Your ref: 3/2016/0711
Our ref:
Date: 11 August 2016

Application No: 3/2016/0711

Proposal: Demolition of an existing building and the erection of two detached dwellings and annex (resubmission of withdrawn application 3/2015/0768).

Location: 9 Downham Road Chatburn BB7 4AU

**Location PLAN**

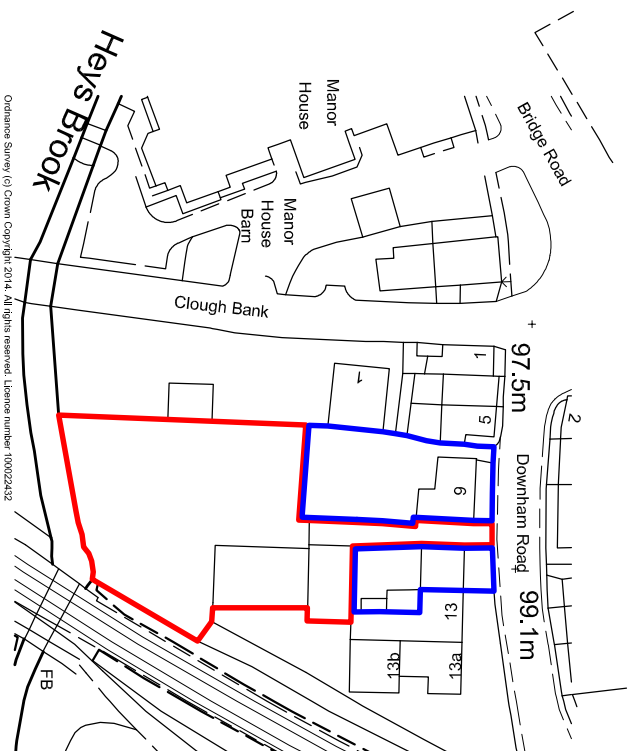
The sight lines of 2.0 x 33m should be provided in both directions from the centre of the site access onto Downham Road. From the information provided on the applicant's site location plan the sight line requirement is fully achievable over the applicant's land and the existing adopted highway. The main issue is ensuring that the sight lines can be secured under condition for perpetuity. The proposed new dwellings will generate more car movements and the new property owners would not be able to ensure the sight lines are maintained over third party land.

SITE PLAN

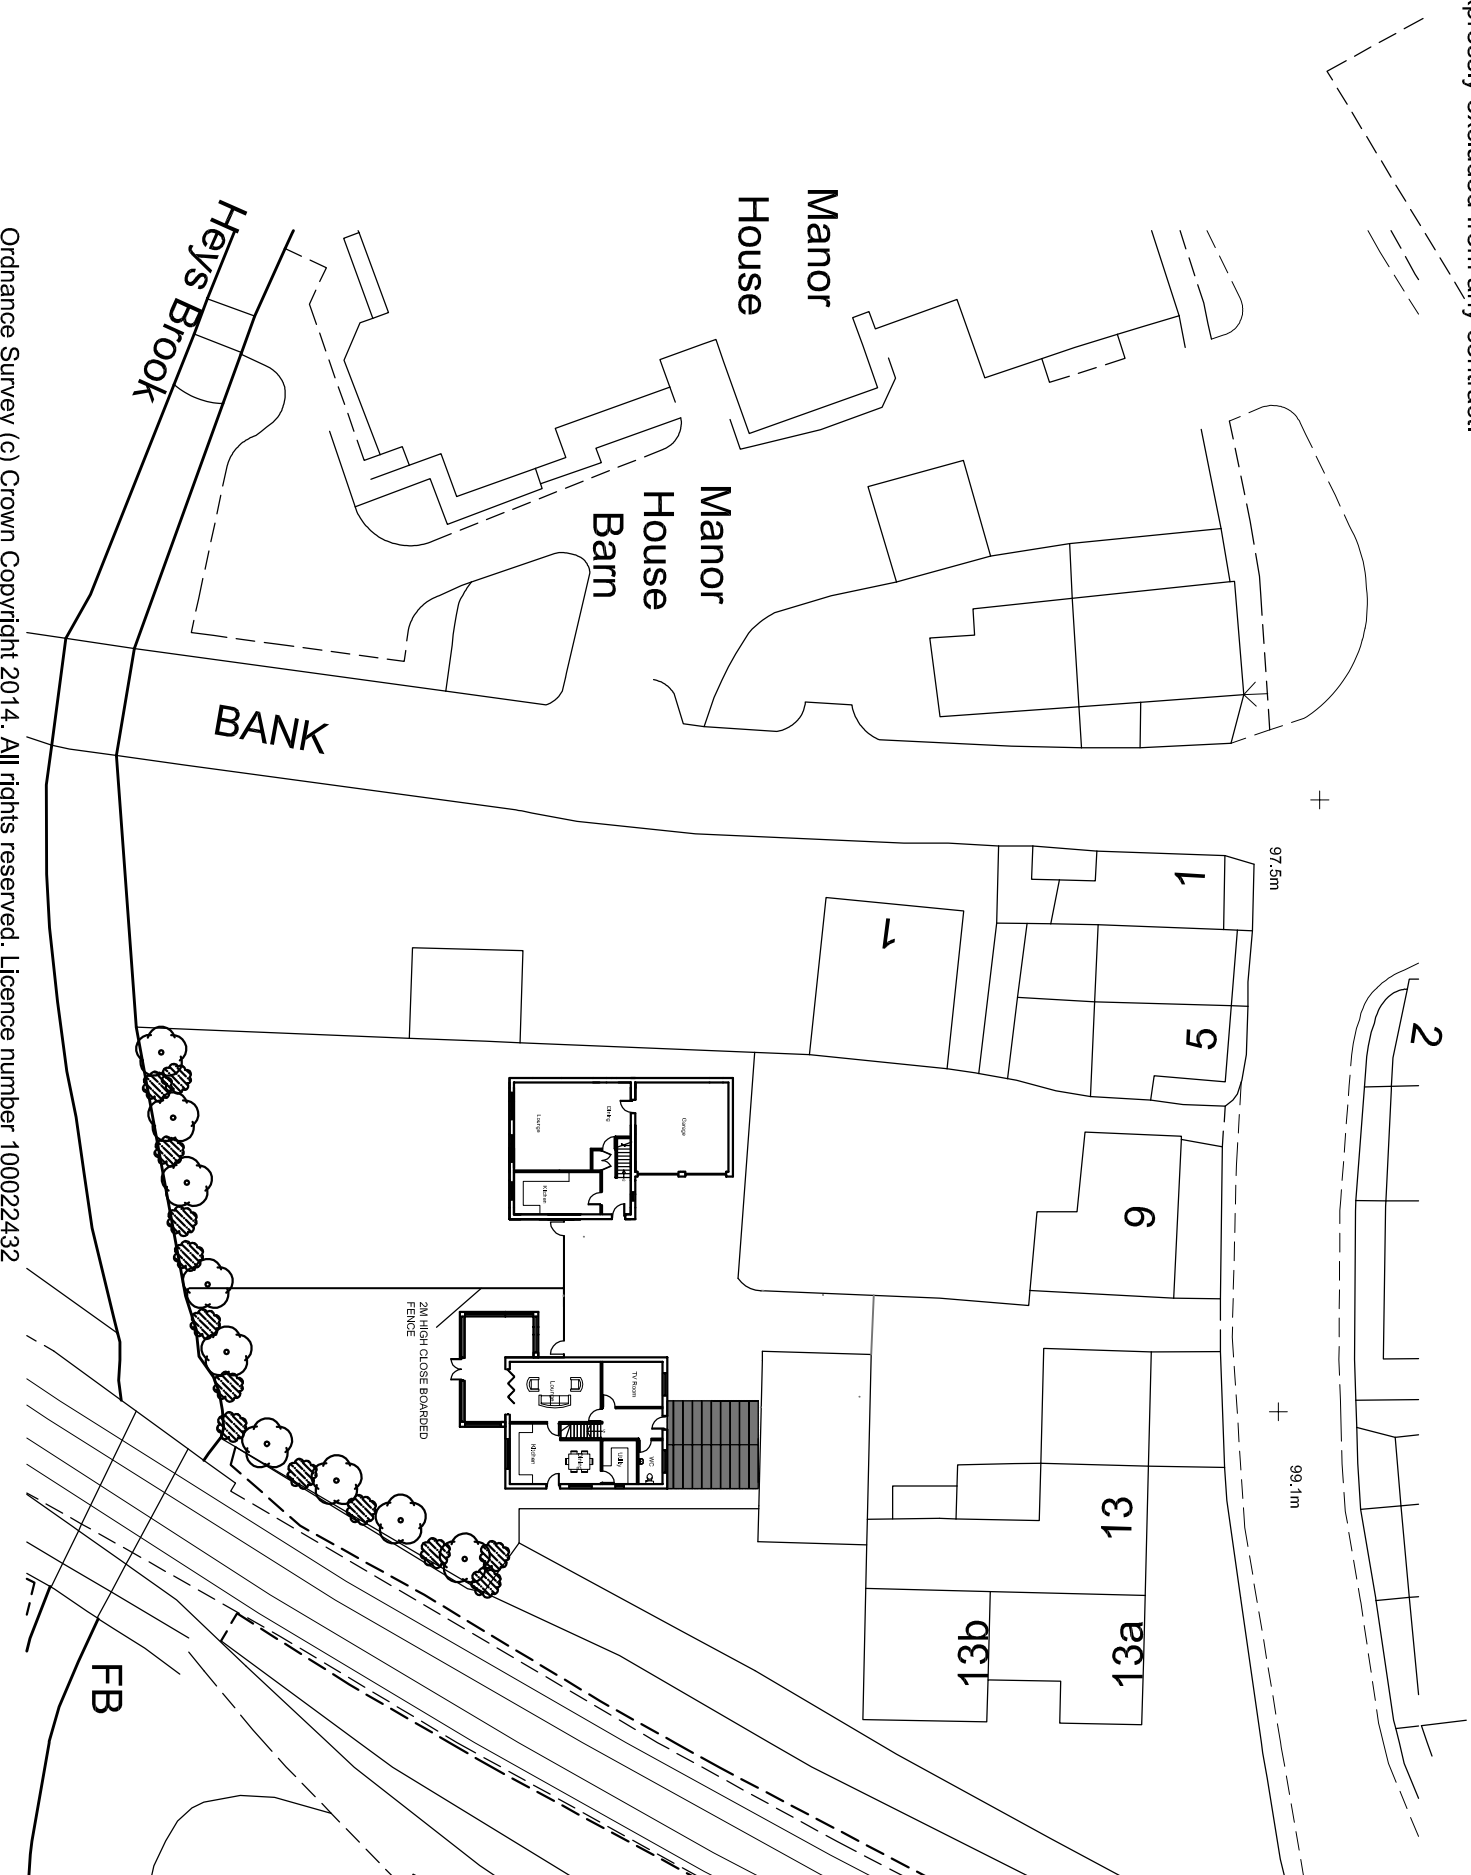
The garage to Plot 1 should have minimum internal dimensions of 6 x 6m to count as two parking spaces.

There should be a minimum distance of 6m between the south elevation of the annex and the north elevation of Plot 2 for the canopy/carport to count as two parking spaces.

1. No part of the development shall be commenced until the visibility splays measuring 2.0 metres by 33 metres in both directions to be provided, measured along the centre line of the proposed new road from the continuation of the nearer edge of the existing carriageway of Downham Road, to the satisfaction of the Local Planning Authority. The land within these splays shall be maintained thereafter, free from obstructions such as walls, fences, trees, hedges, shrubs, ground growth or other structures within the splays in excess of 1.0 metre in height above the height at the centre line of the adjacent carriageway. Reason: To ensure adequate visibility at the site access in the interest of highway safety.

2. The car parking and manoeuvring scheme to be laid out in accordance with the approved plan, before the use of the premises hereby permitted becomes operative and permanently maintained thereafter. Reason: To allow for the effective use of the parking areas.

3. The layout of the development shall include provisions to enable vehicles to enter and leave the highway in forward gear and such provisions shall be laid out in accordance with the approved plan and the vehicular turning space shall be laid out and be available for use before the development is brought into use and maintained thereafter. Reason: Vehicles reversing to and from the highway are a hazard to other road users.

6. Before the access is used for vehicular purposes, that part of the access extending from the highway boundary for a minimum distance of 10m into the site shall be appropriately paved in bound porous material. Reason: To prevent loose surface material from being carried on to the public highway thus causing a potential source of danger to other road users.
